From: studio-lets [REDACTED]
Sent: 04 September 2018 17:02
To: Simon Davis <Simon.Davis@arun.gov.uk>
Subject: RE: AL/136/17/PL Fontwell Avenue

From: Simon Davis <Simon.Davis@arun.gov.uk>
Sent: 04 September 2018 12:55
To: 'studio-lets' [REDACTED]
Cc: 'DAVE PARKER' [REDACTED]
Subject: AL/136/17/PL Fontwell Avenue

FIRM NAME ELLIS ASSOCIATES (BEXLEY) LTD 07939 129938	
CLIENT & LOCATION MS E PARKER LAND AT FONTWELL AVENUE EASTERGATE CHICHESTER PO20 3RU	
PROJECT 2'No FOUR BEDROOM SEMI-DETACHED DWELLINGS	
SCALE: 1:500 DATE: MAY 18	DRG NO: CHI/17089/P 3 OF 3

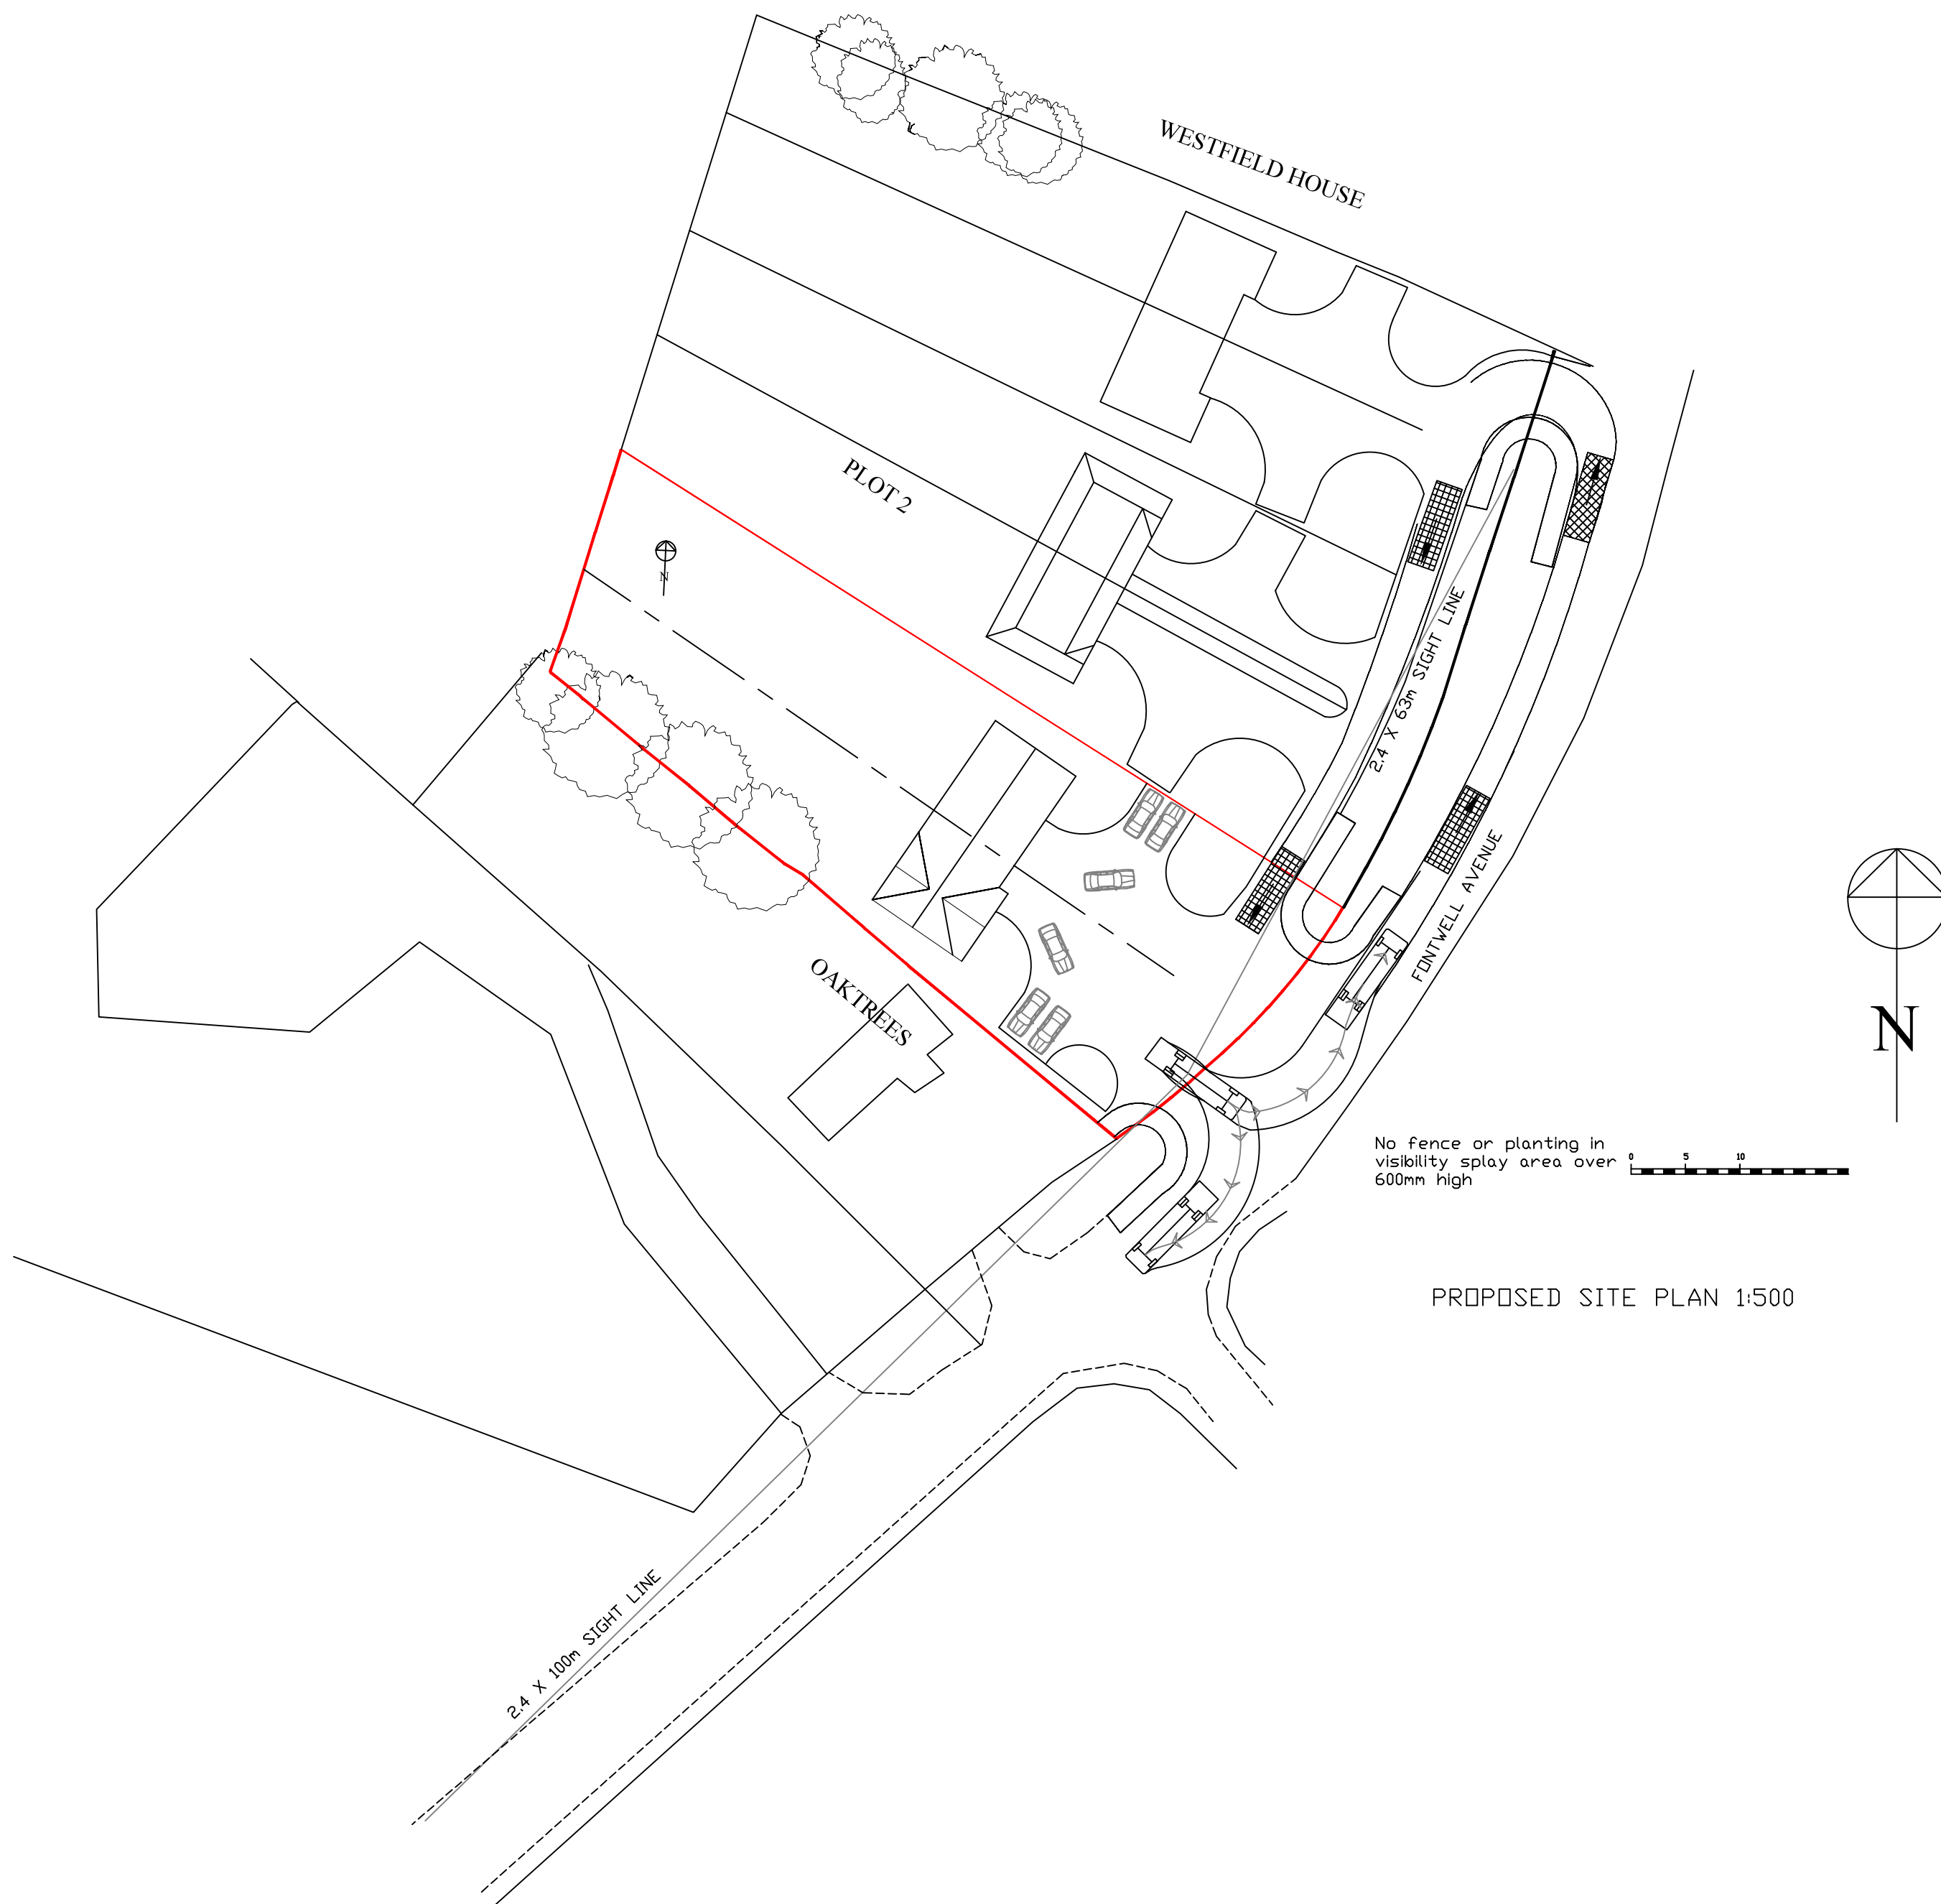
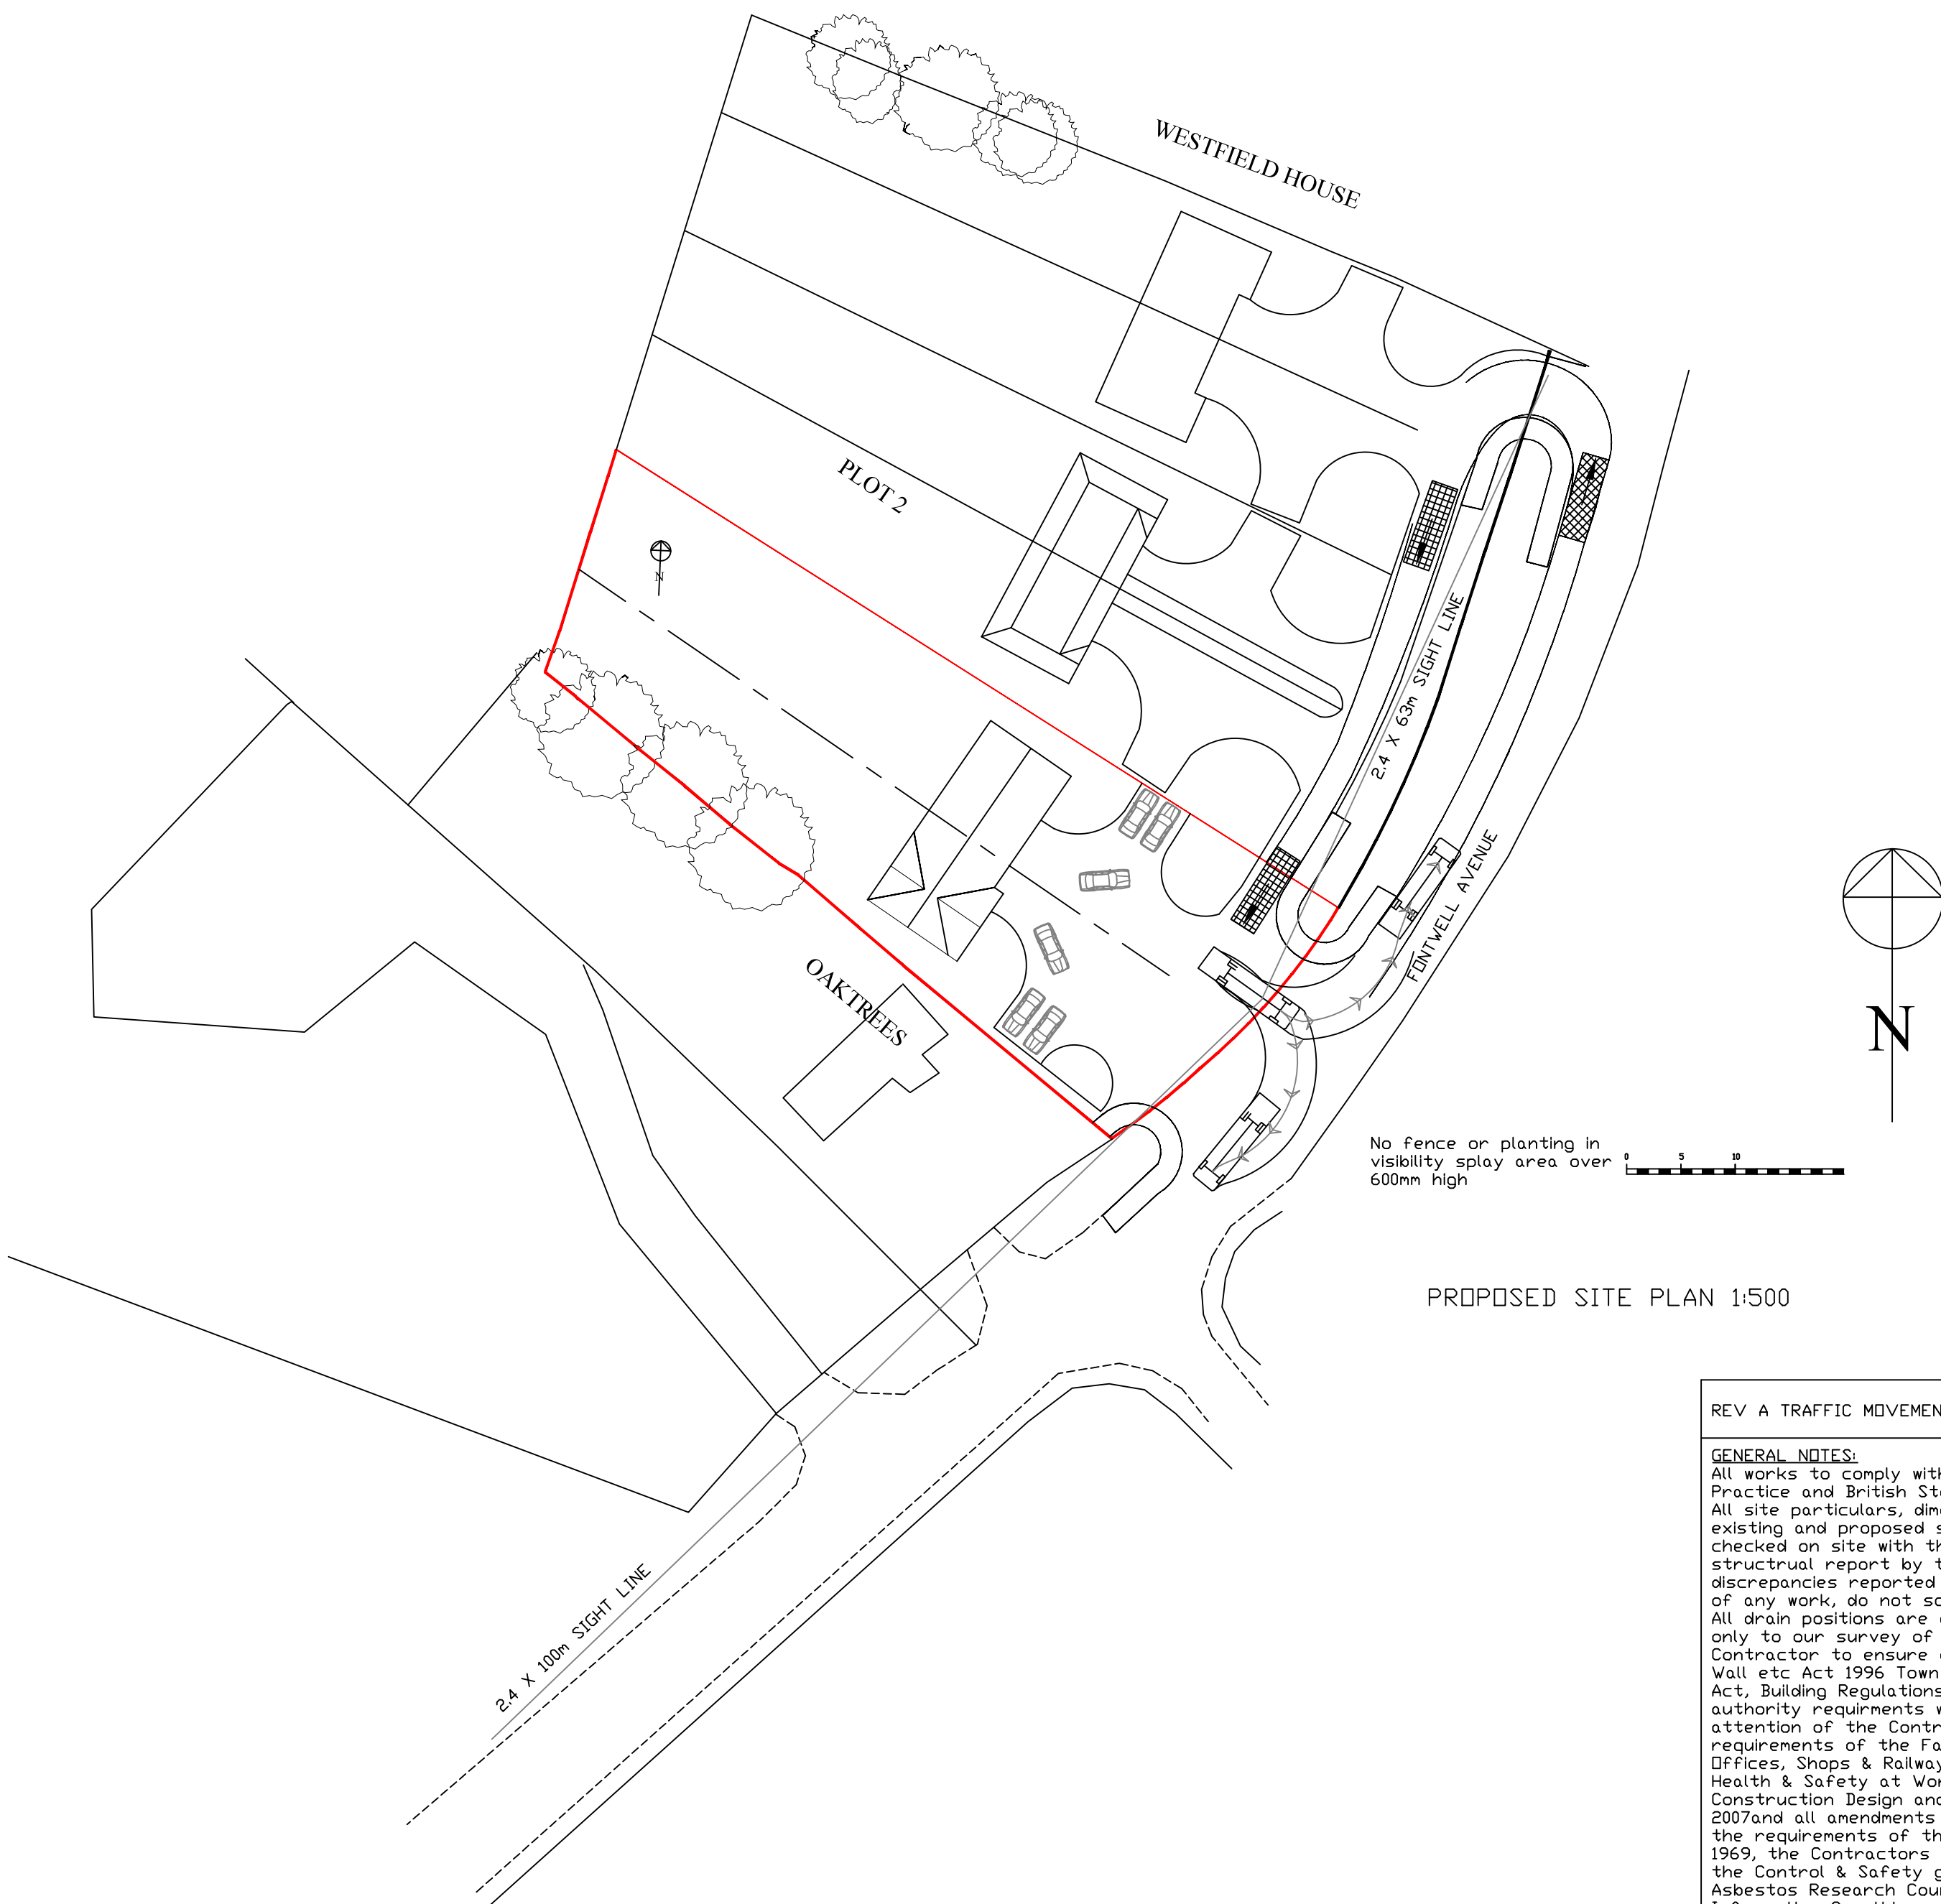
1. Amend the red edge on drawings CHI/17089/P 2 OF 3 Rev A "Site Location Plan, Proposed Site Plan & Proposed Elevations" and CHI/17089/P 3 OF 3 Rev A "Proposed Site Plan" so that it matches with the red edge drawn on the visibility splay drawing (RGP drawing 2018-4370-001 Rev A). Can you ensure the two drawings are both labelled as Rev B.
2. Can you also serve notice on Mr Norgate the owner of the middle plot concerning the incursion of your red edge into his plot -- and provide us with the copy of the notice service form (blank form attached for ease).
